CITY OF ALBUQUERQUE

July 14, 2021

Re: ASI
4500 Paseo Del Norte NE
Traffic Circulation Layout
Architect's Stamp 07-07-2021 (D17-D110)

A-353

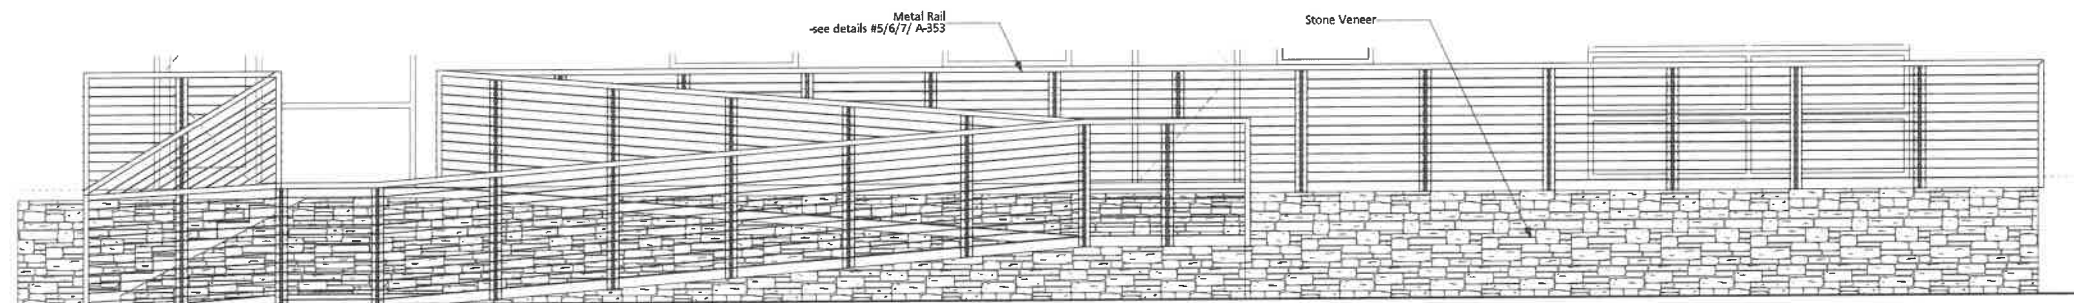
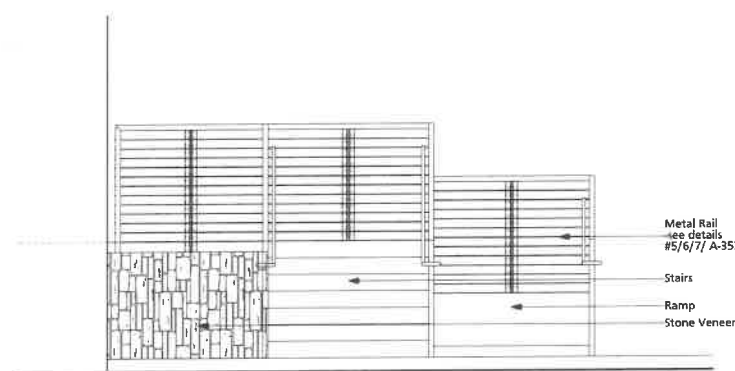
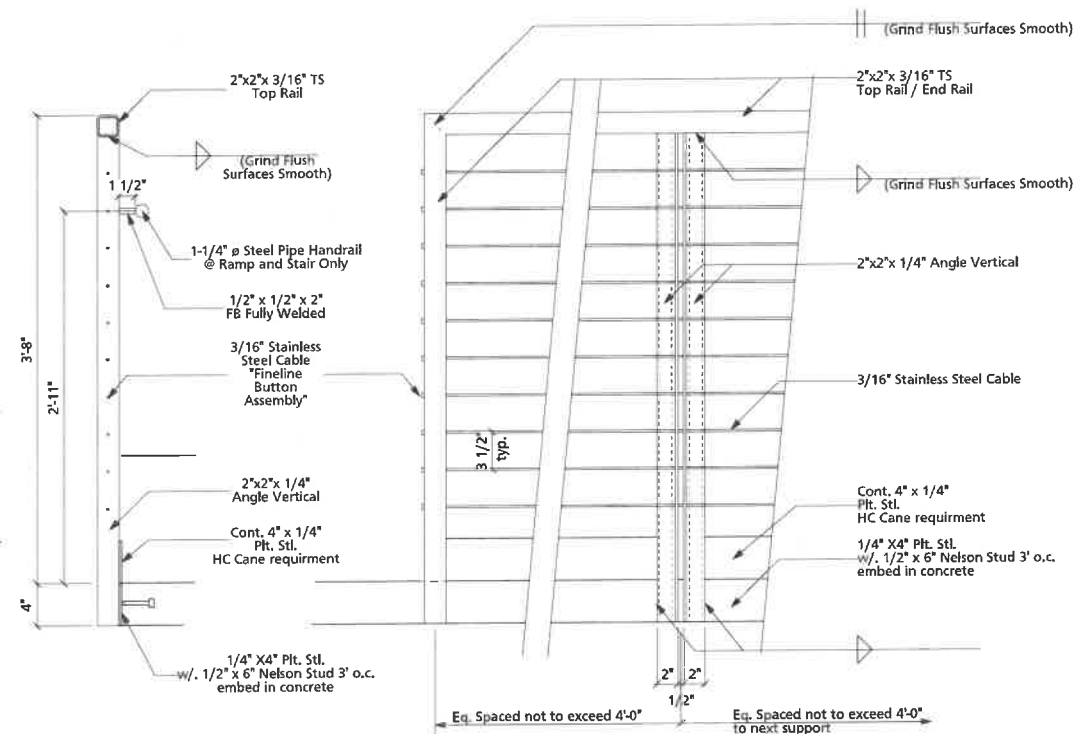
2. Per DPM, a 6 ft. wide ADA accessible pedestrian pathway is required from the ADA parking stall access aisles to the building entrances. **Please clearly show this pathway and provide details (Details to include ADA ramp and possibly handrails: also provide dimensions and slopes).**
You need to address this concern and provide details on this subject as stated on prior comments.

TCL

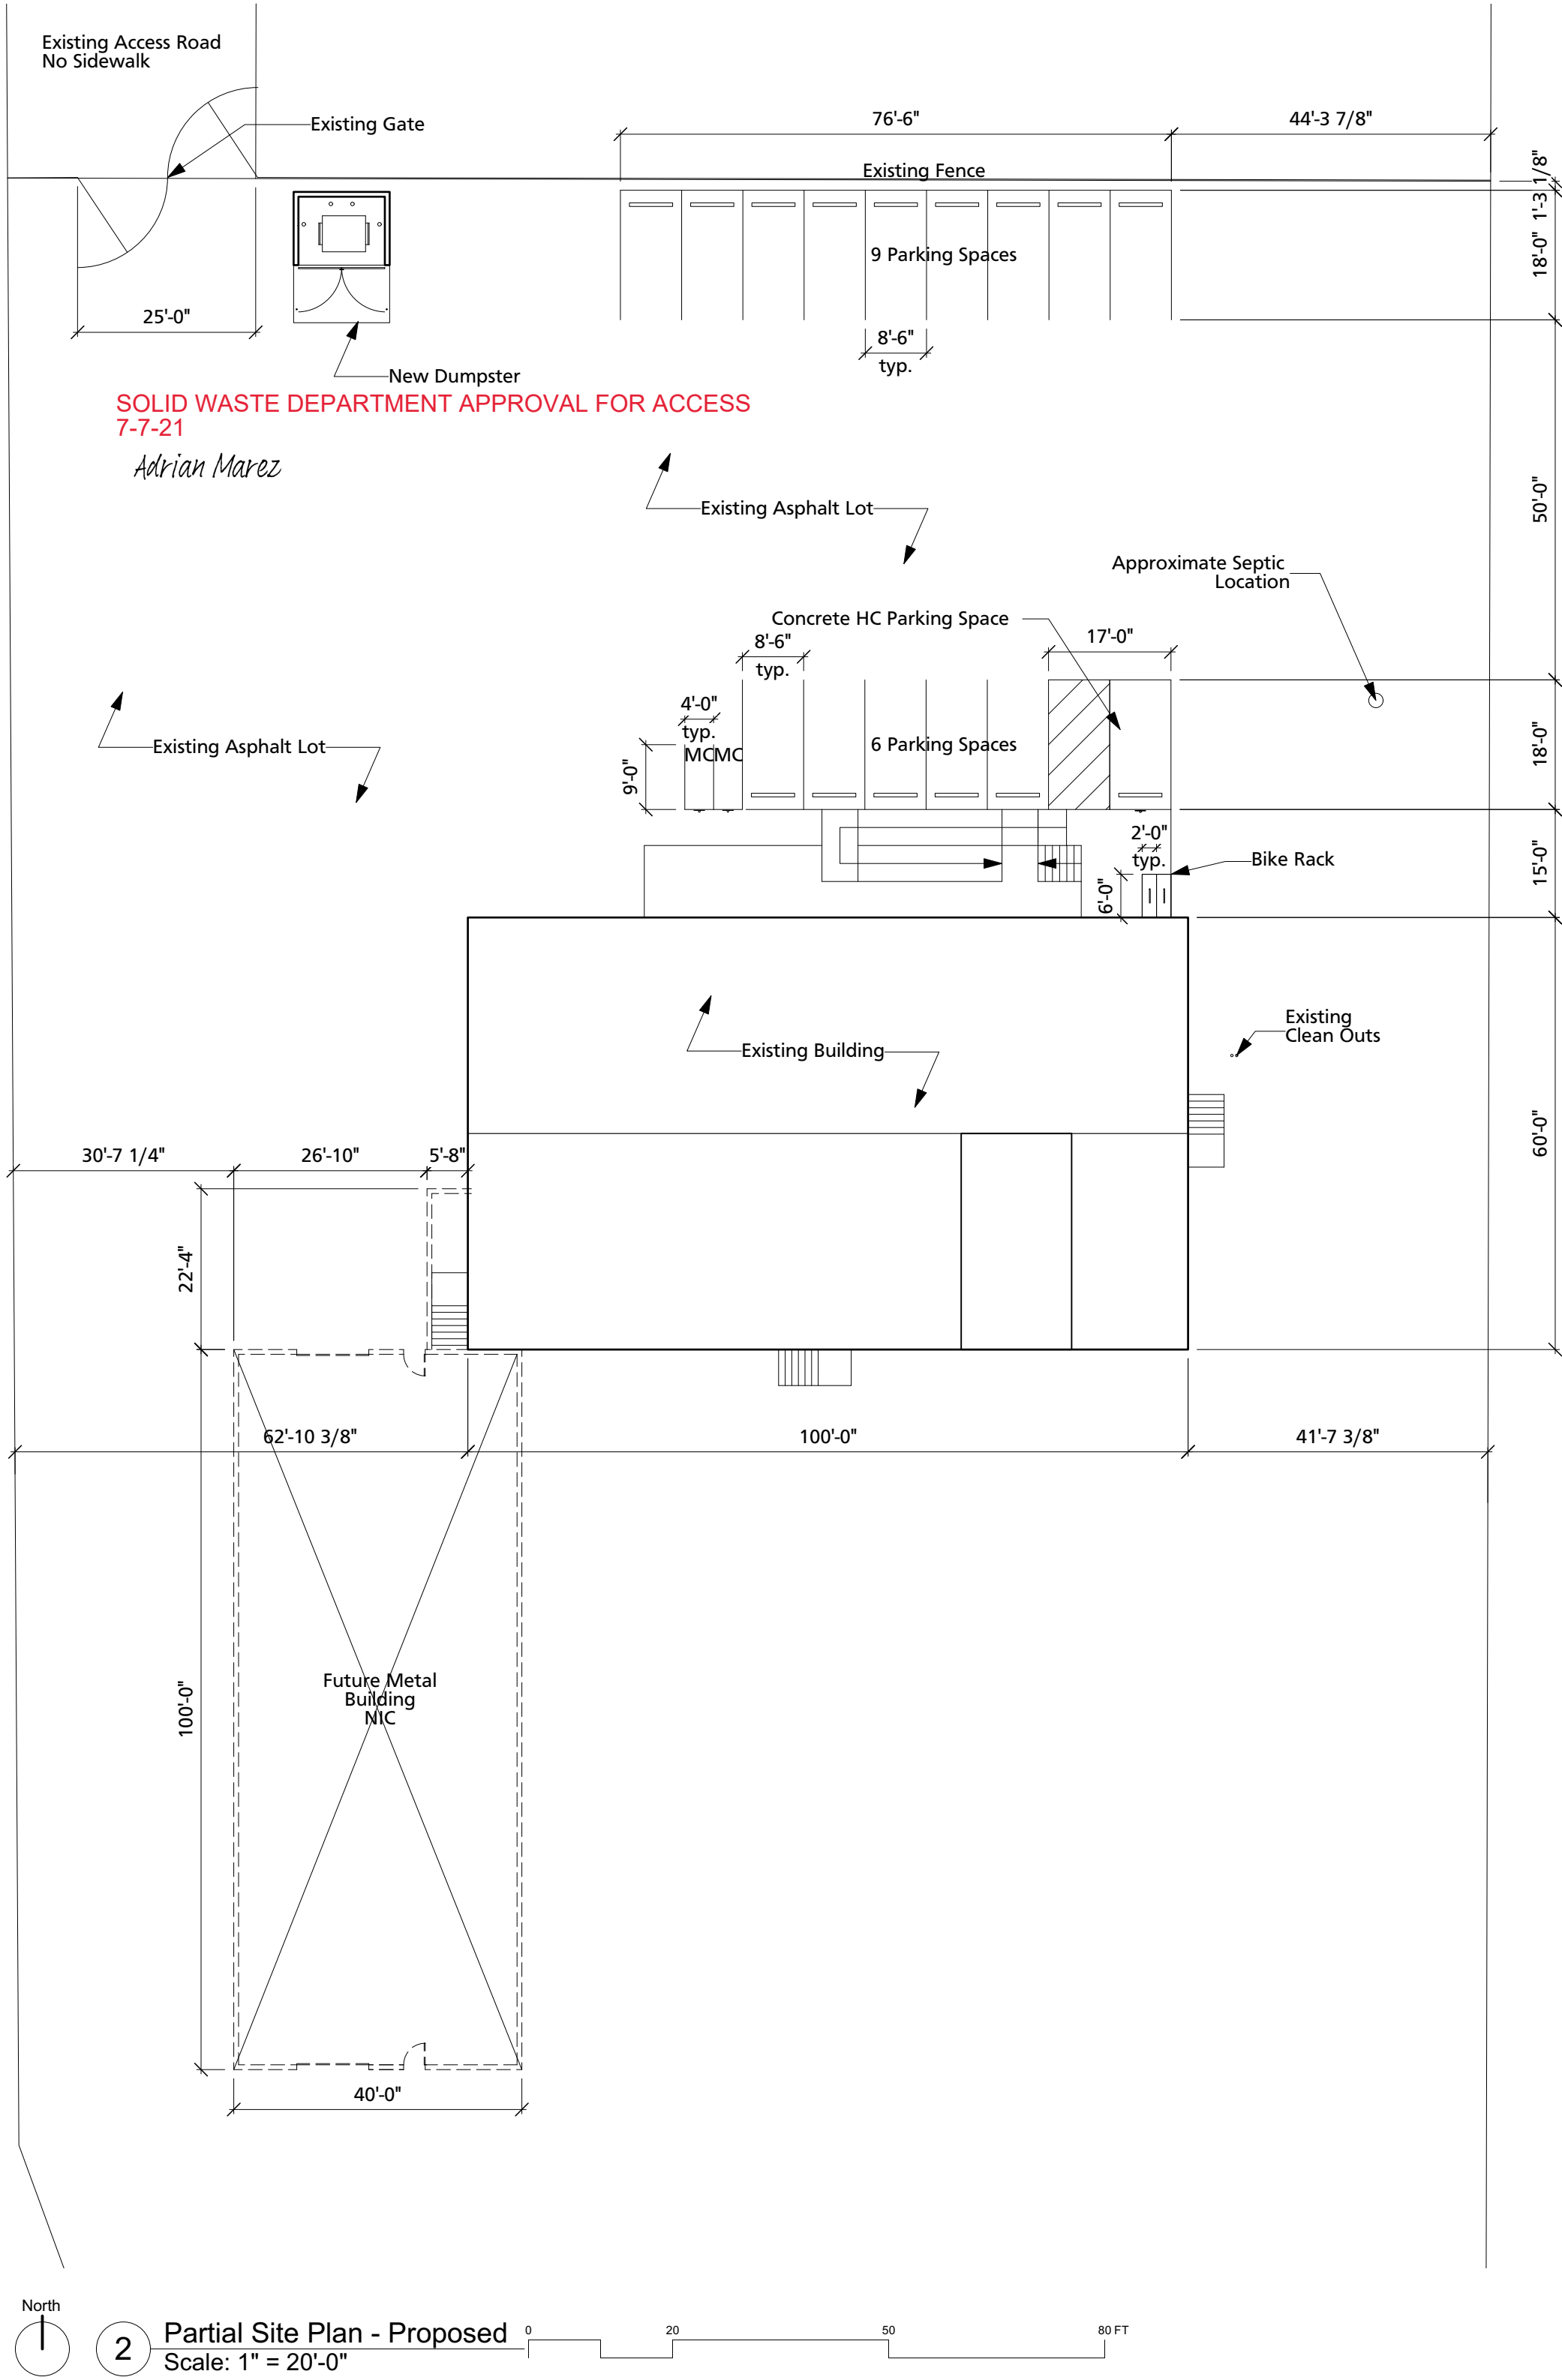
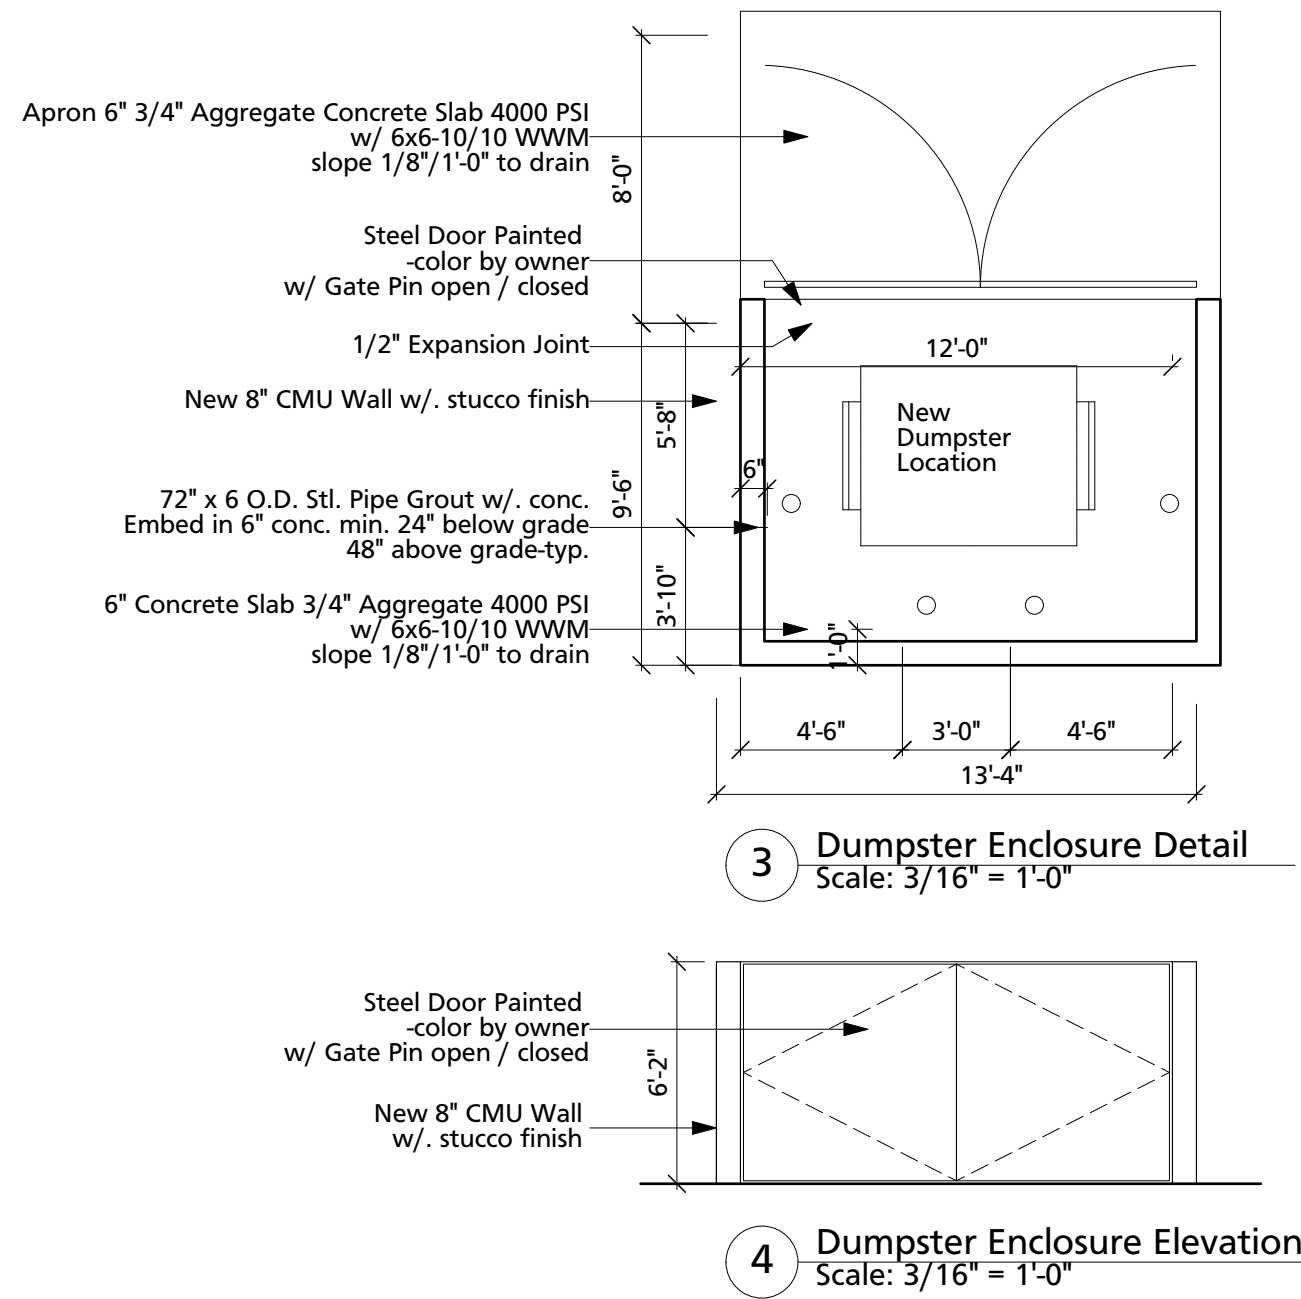
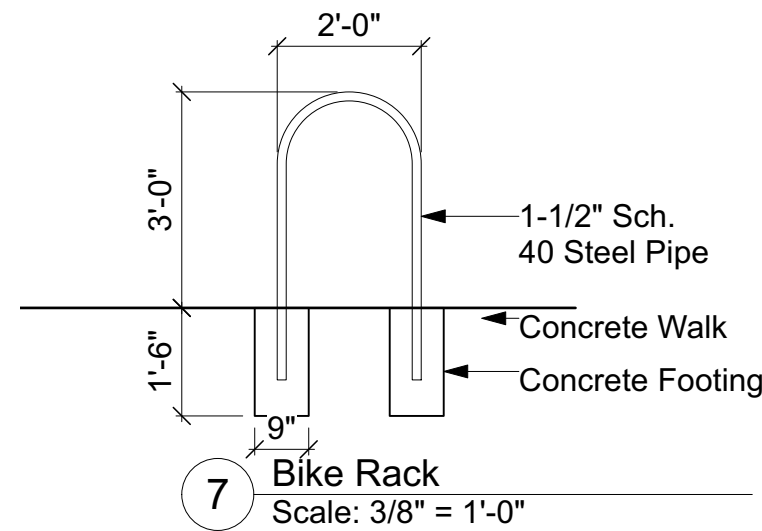
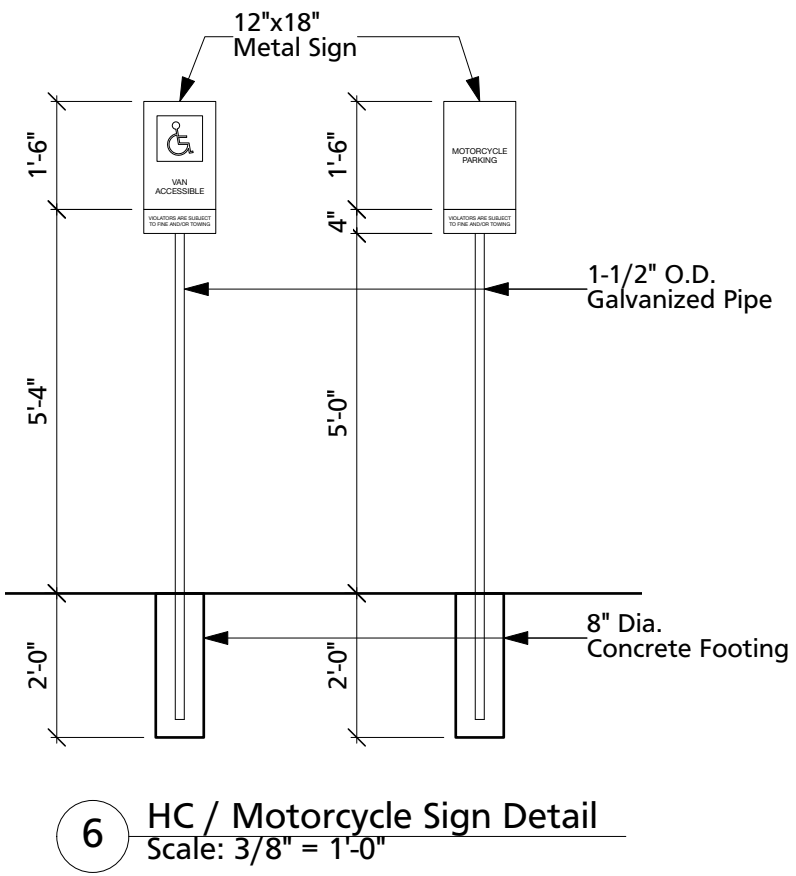
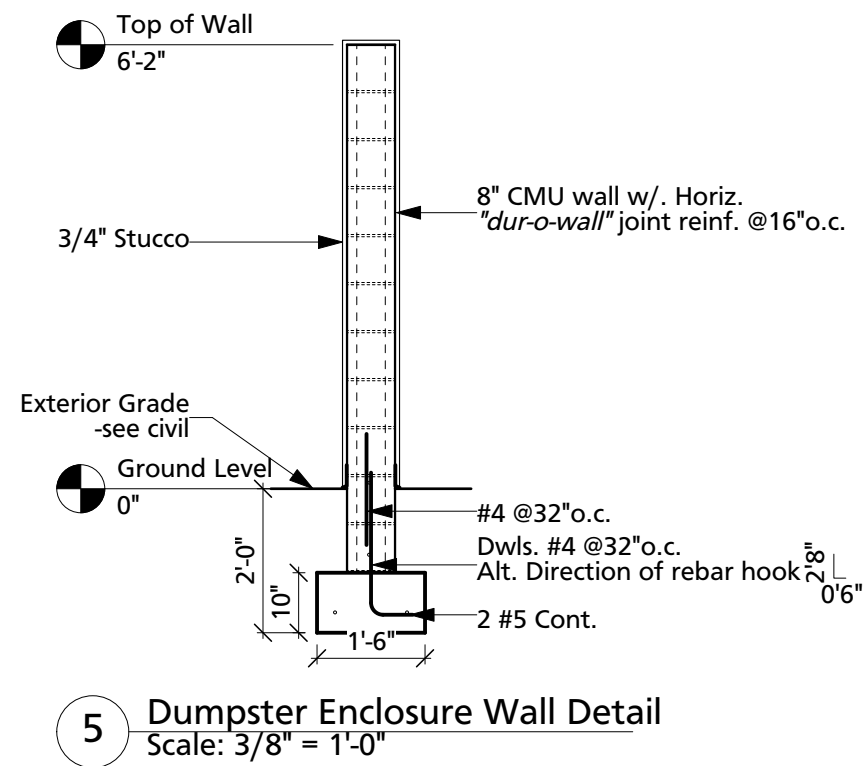
- **Review DPM** for the private **access roadway width** and **sidewalk requirements**.
- Per the IDO, a 6 ft. wide ADA accessible pedestrian pathway is required from the public sidewalk to the building entrances. Please clearly show this pathway and provide details. If applicable and if sidewalk requirements mandate or not.
- All sidewalks along streets should be placed at the property line (if applicable).

3. Detail for parking bumpers/barriers need to be provided.
4. Please provide a letter of response for all comments given.
5. Provide a copy of receipt for the resubmittal fee payment.
